**Harbourside Shopping Centre Redevelopment SSD-7874  
Amended Concept Proposal and Stage 1 Early Works October 2020 and  
Response to submissions**

My submission is to OBJECT based on the grounds that the minor changing to the northern podium do not:

Image 82 Envelope Plan

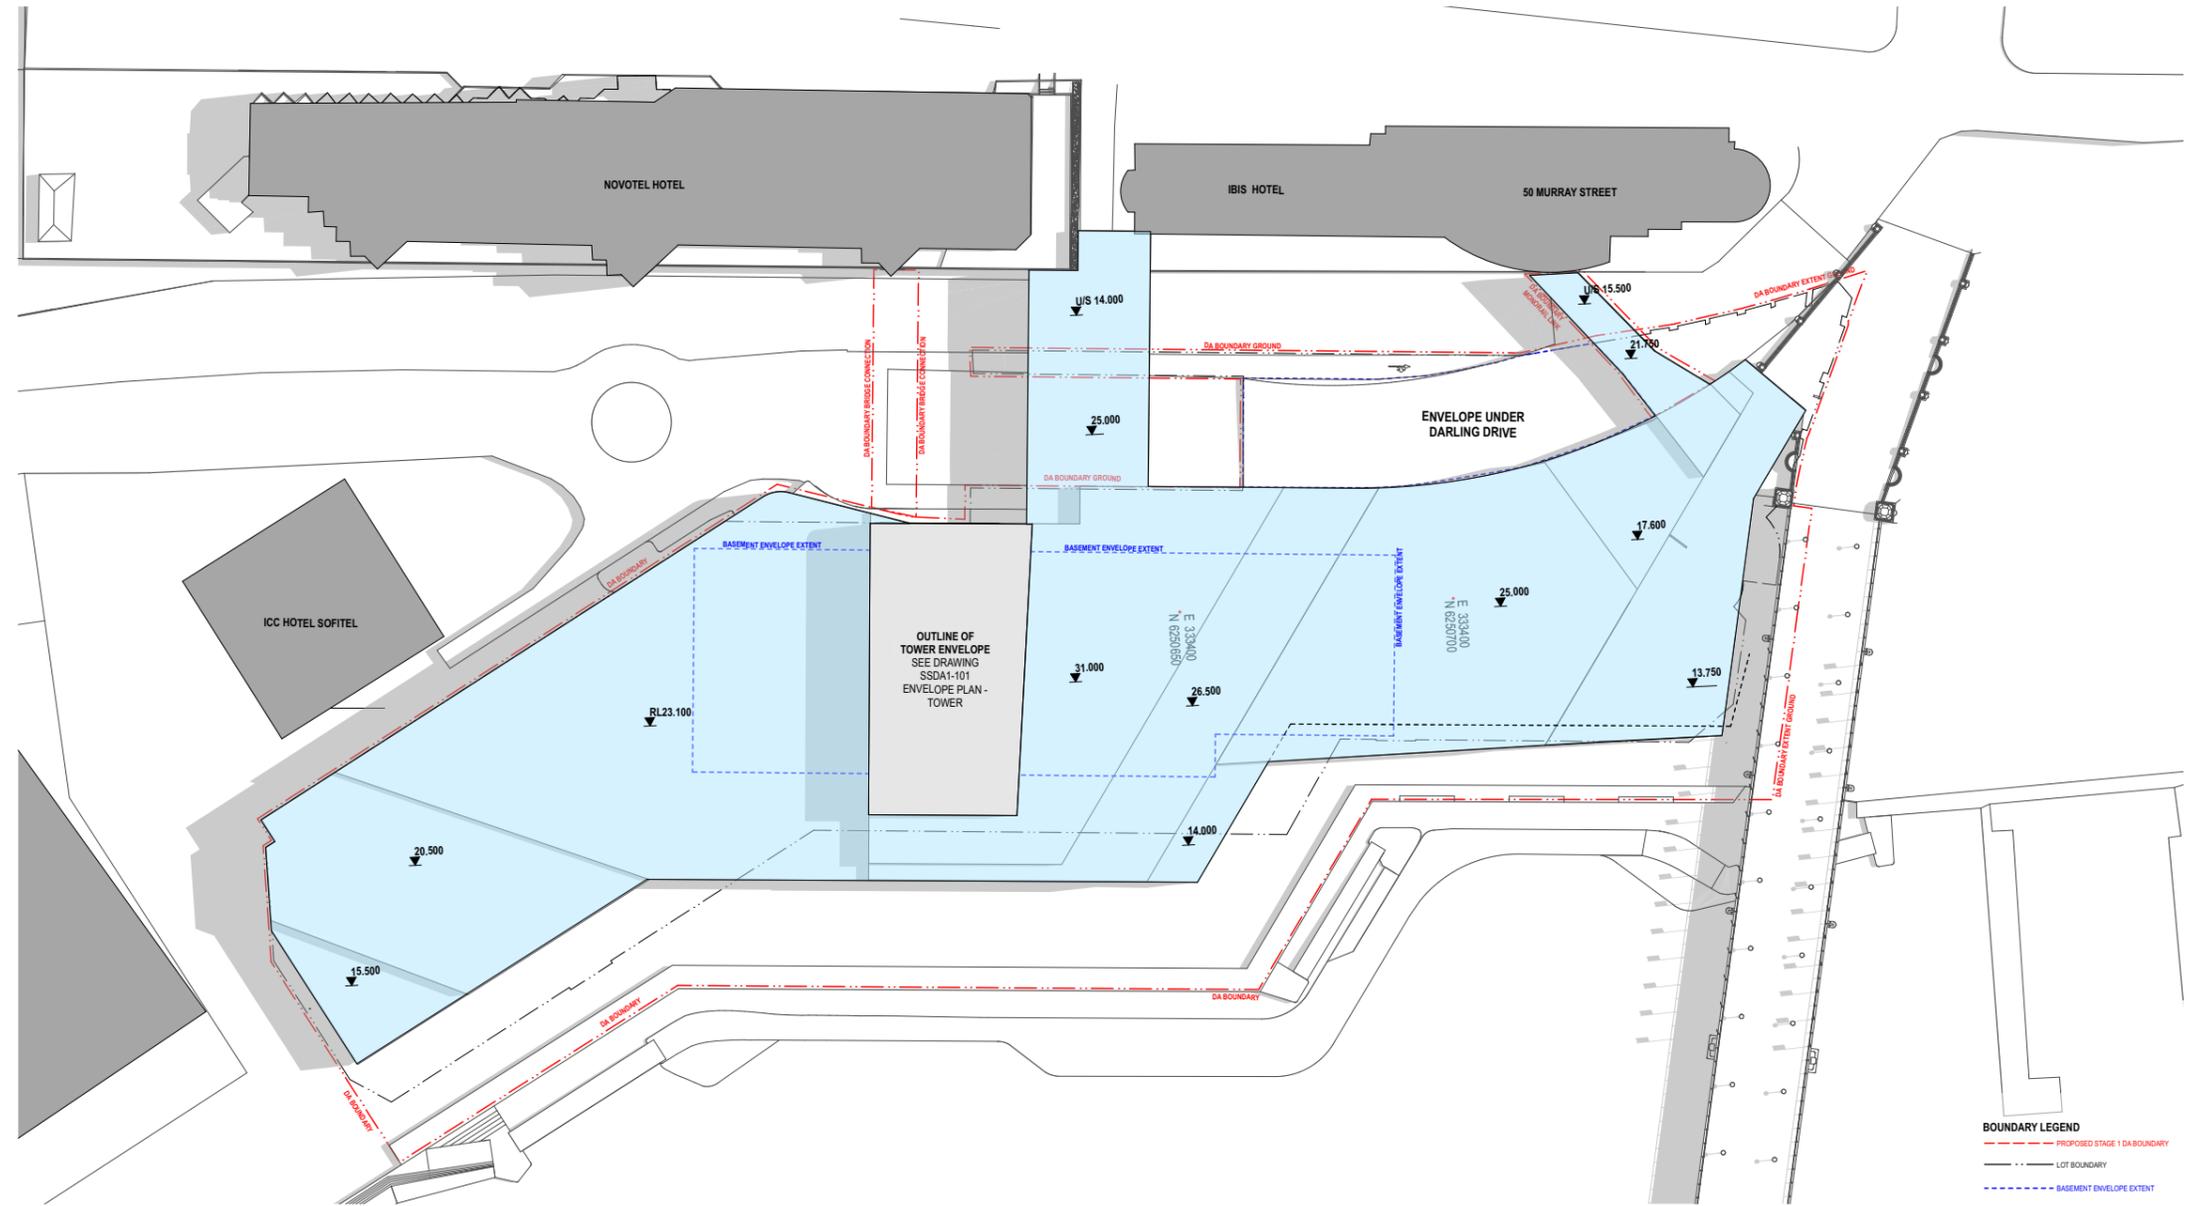
The majority of the **east facing** apartments of 50 Murray Street have highly valued views that enjoy **whole water views of Cockle Bay**. Every aspect (Floor to ceiling glass) of the apartments, in addition to the balcony, have a view of the water. With the previous concept, all east facing apartments at level 8 and below totally lost all Cockle Bay views. The amended concept as shown below still has east facing apartments losing all Cockle Bay water views.

The proponent claims that by introducing a north east facing 'channel' it provides views north of Pyrmont Bridge and thus claims it has '*significant improved view sharing of 50 Murray Street*'. This is an **unacceptable claim**. It has been pointed out that east faced of 50 Murray Street is a curved. Providing a north east channel at the north end of the proposal has no impact on sharing the water views of Cockle Bay.

*Views from curved 50 Murray Street are inconsistent with the provision of a channel view platform to the north east claiming to have '*significantly improved view sharing of 50 Murray Street*'*
